KITTITAS VALLEY FIRE & RESCUE

KVFR Prevention Comments

Project: Apostolic Faith United

Permit#: CU-22-00001

MAIN LEVEL FLOOR PLAN HOUSE: 5,750 SQ. FT. SCALE: 1/4" = 1'-0"

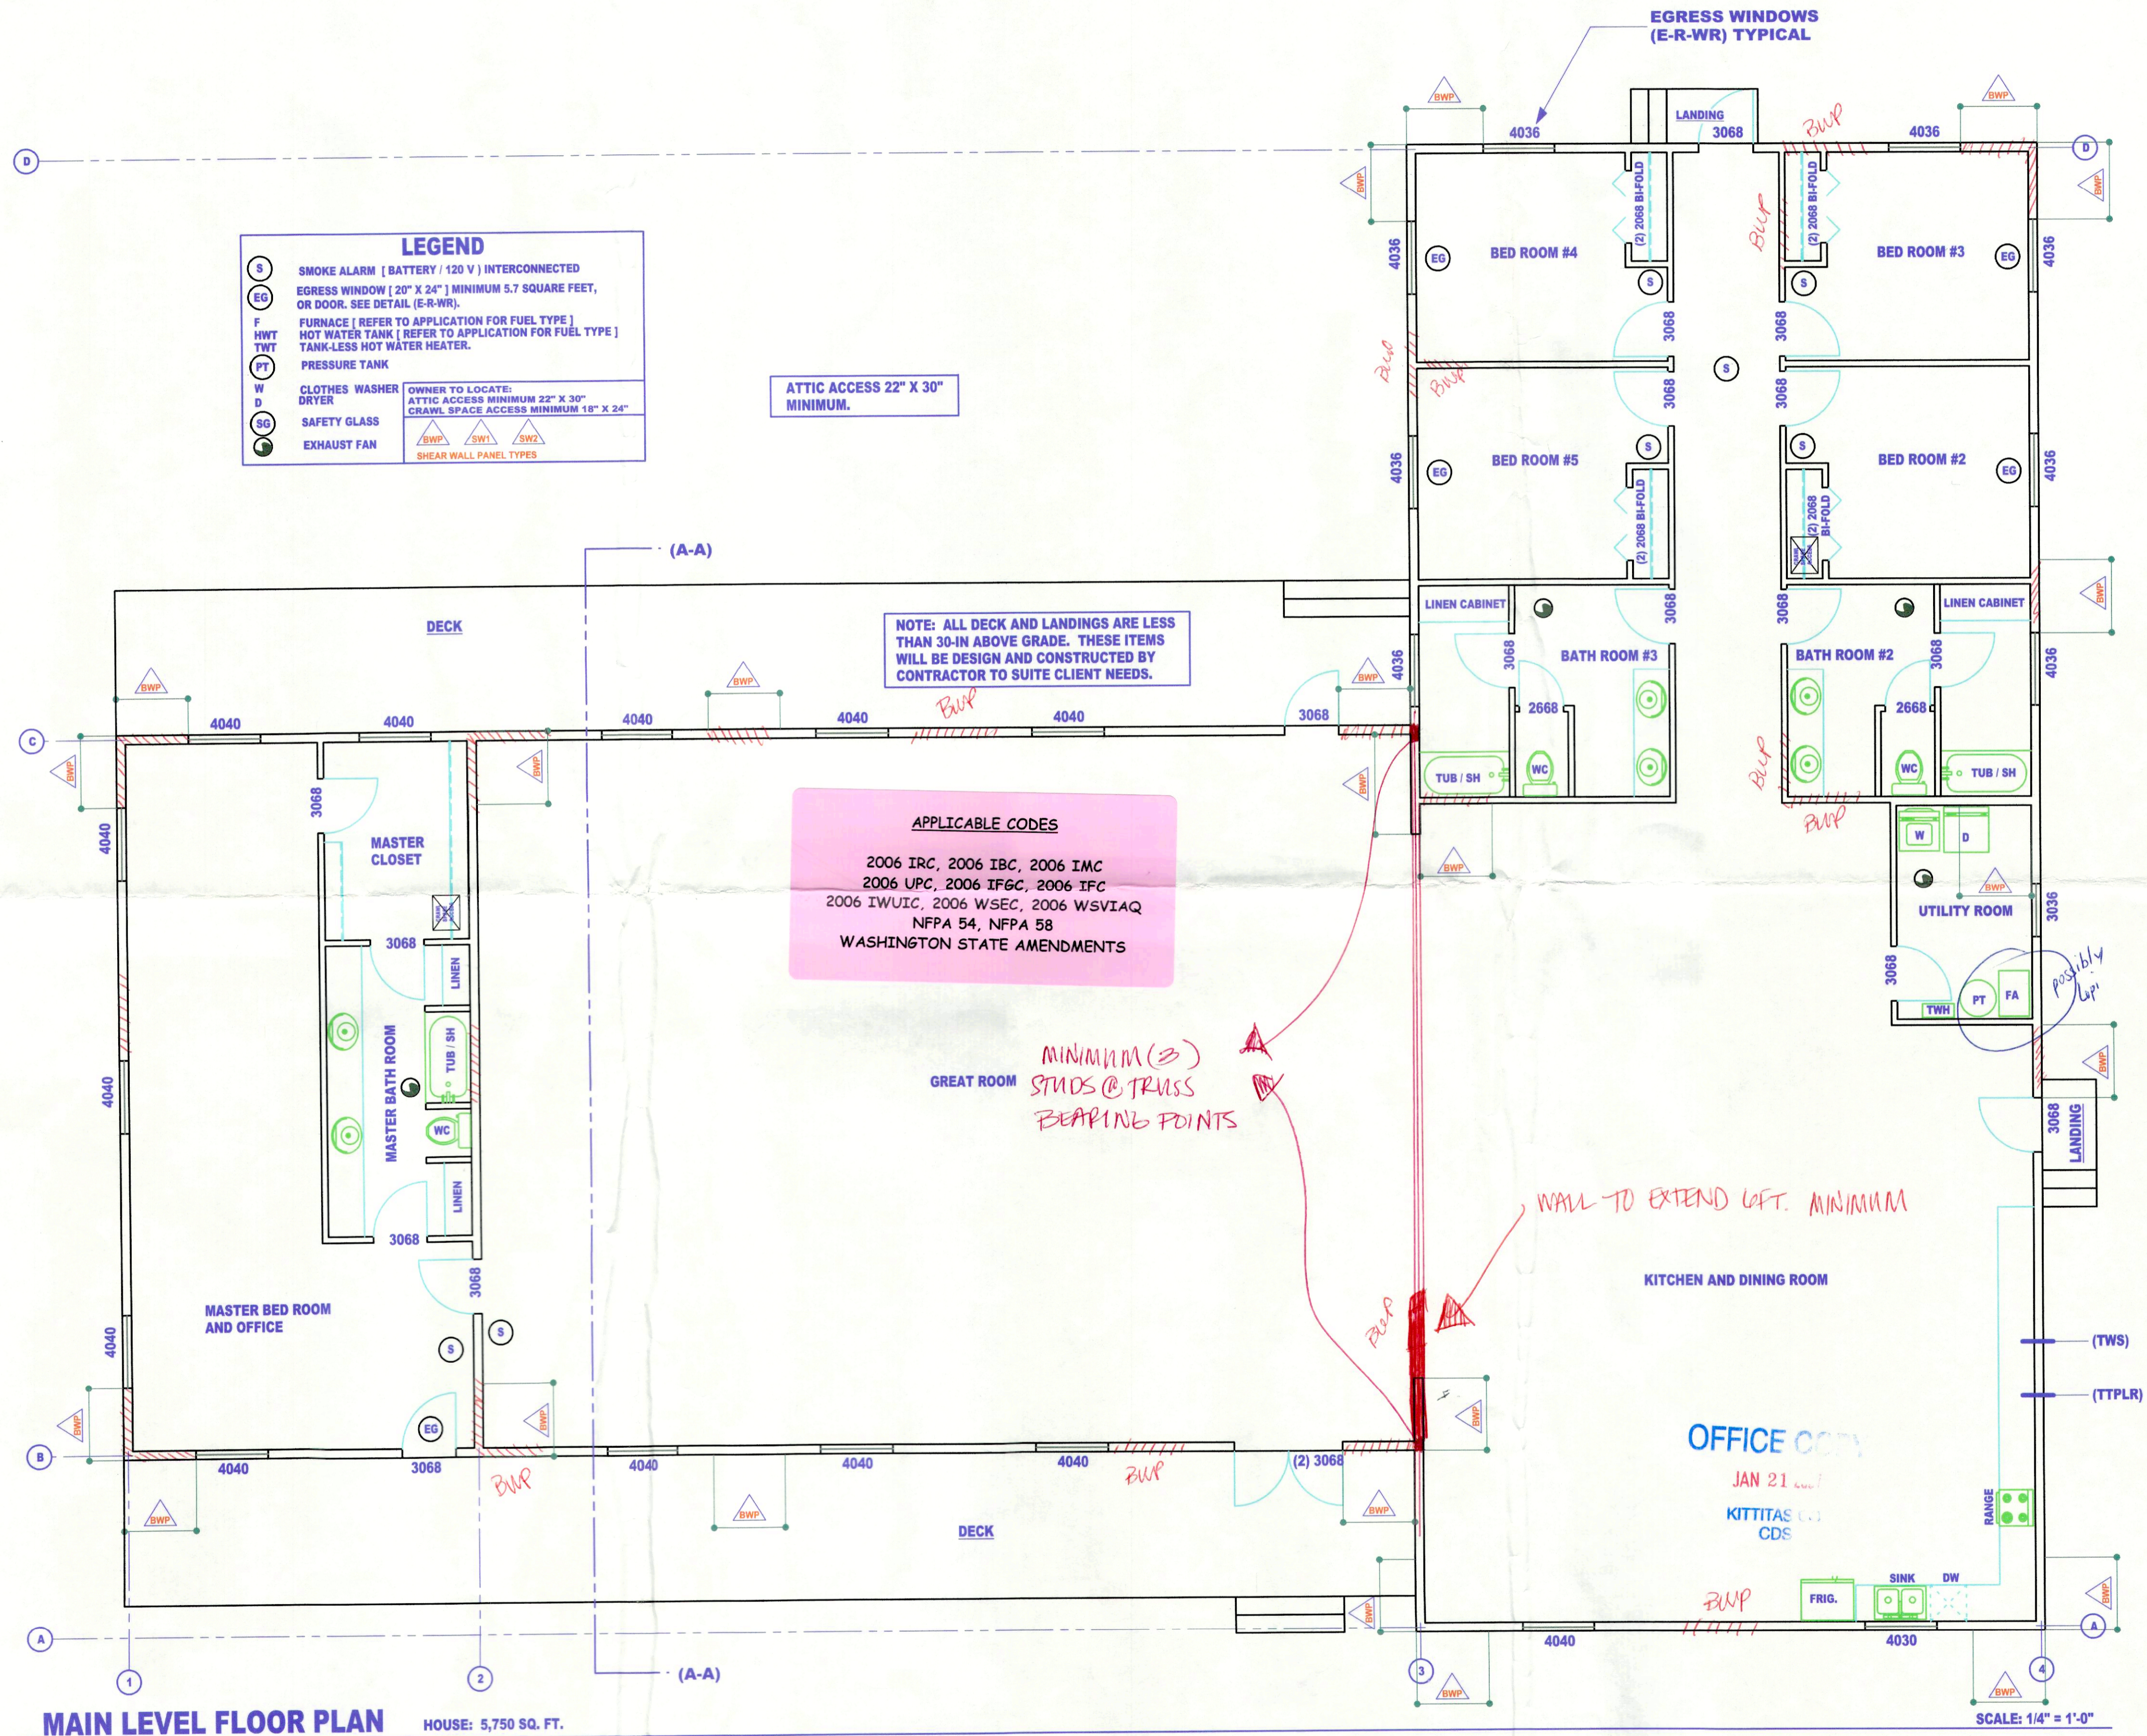
- Knoxbox requirements per building, one installed to the right of the main entrance on the address side, 3-5' above final grade.
- Fire extinguisher quantity and placement per IFC section 906

- IFC EXIT requirements per Chapter 10 based on occupancy to include:
 - ✓ Quantity
 - ✓ Door swing
 - ✓ Door Hardware
 - ✓ Illuminated EXIT signage
 - ✓ Egress path Illumination

- ✓ Travel distance
- A Type I Kitchen hood with fire suppression may be required based on intended use.
- Maximum Occupancy signs posted at the door to all assembly spaces.

SITE PLAN
WALTER DAVENPORT
(17-19-08055-0002)
SCALE: 1" = 120'

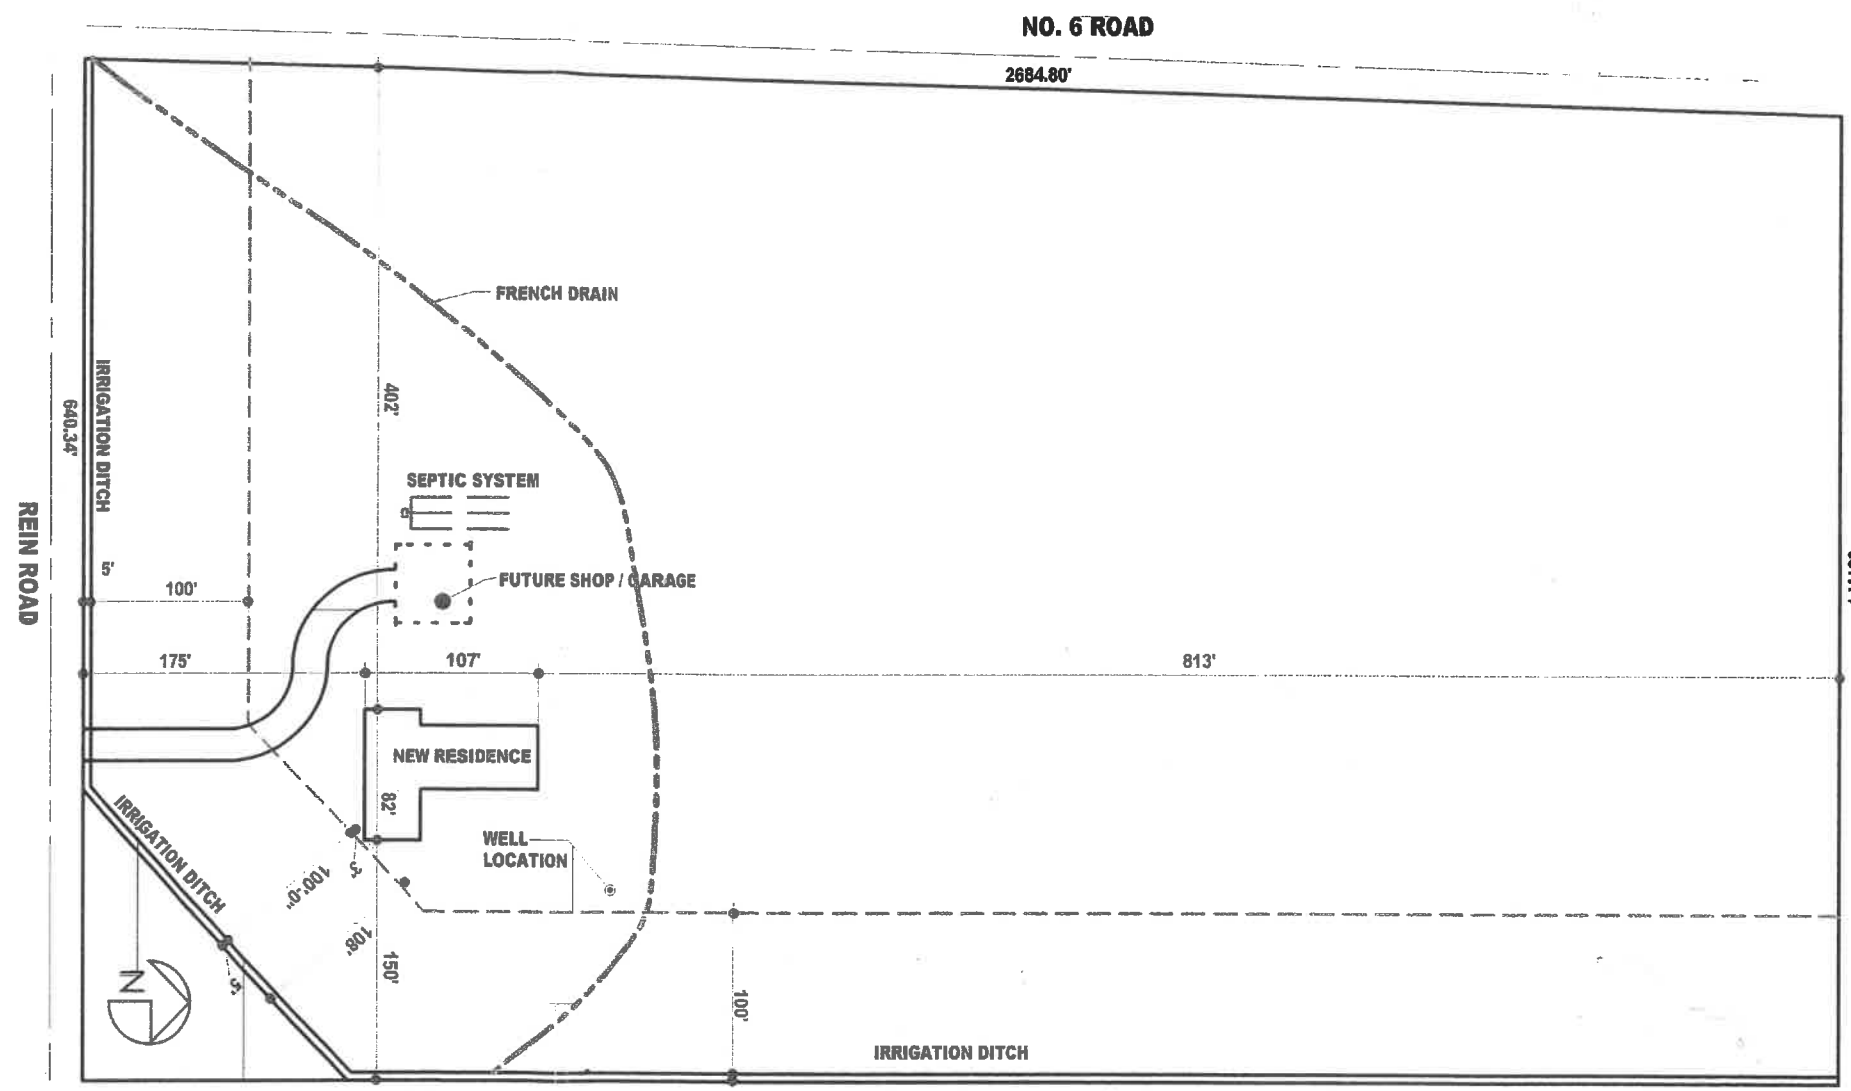
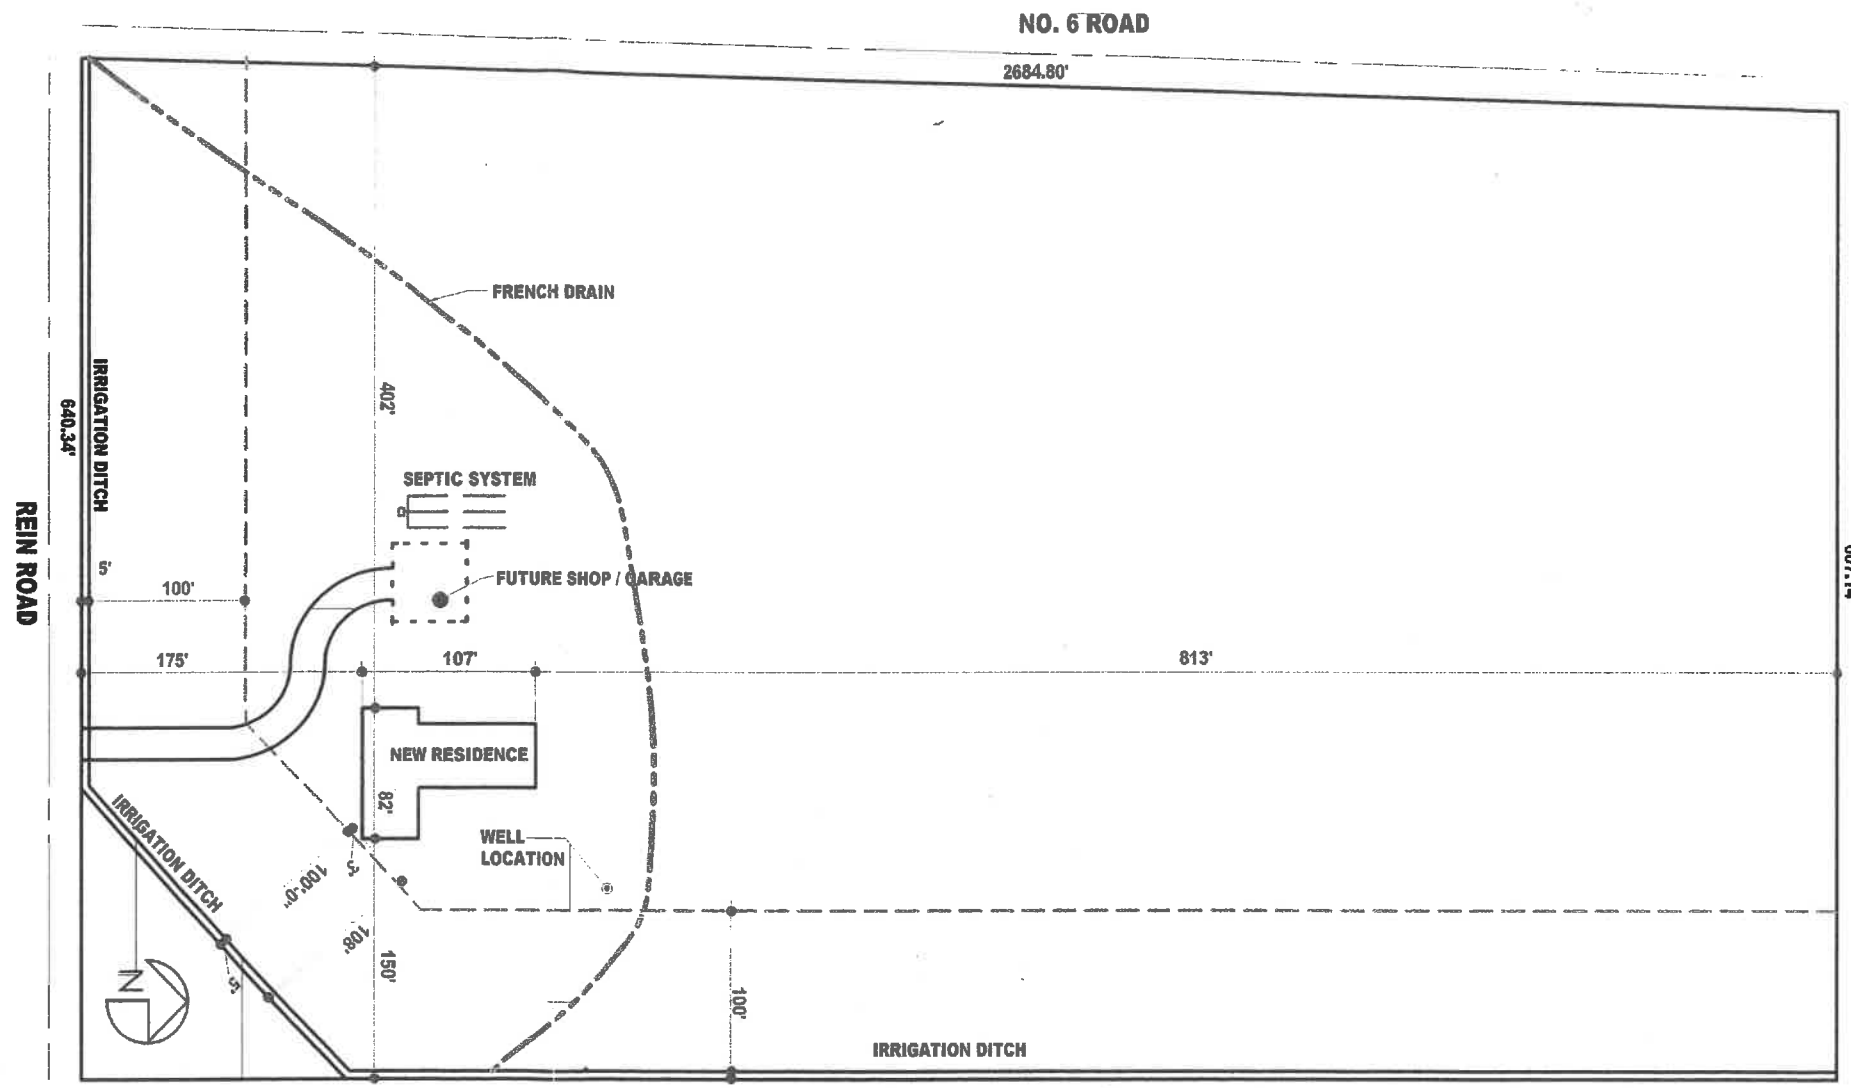
- Fire apparatus access roads exceeding 150' shall be provided with a temporary or permanent turnaround meeting the requirement 2018 IFC Appendix D.
- Fire apparatus access roads shall not exceed 10% in grade. This is especially critical in our valley's climate.

- The IFC Appendix D requires the road be a minimum of 20' wide and capable of supporting an imposed load of at least 75,000 lbs.
- Our standard turning radius is a minimum of 23' inside and 45' outside.
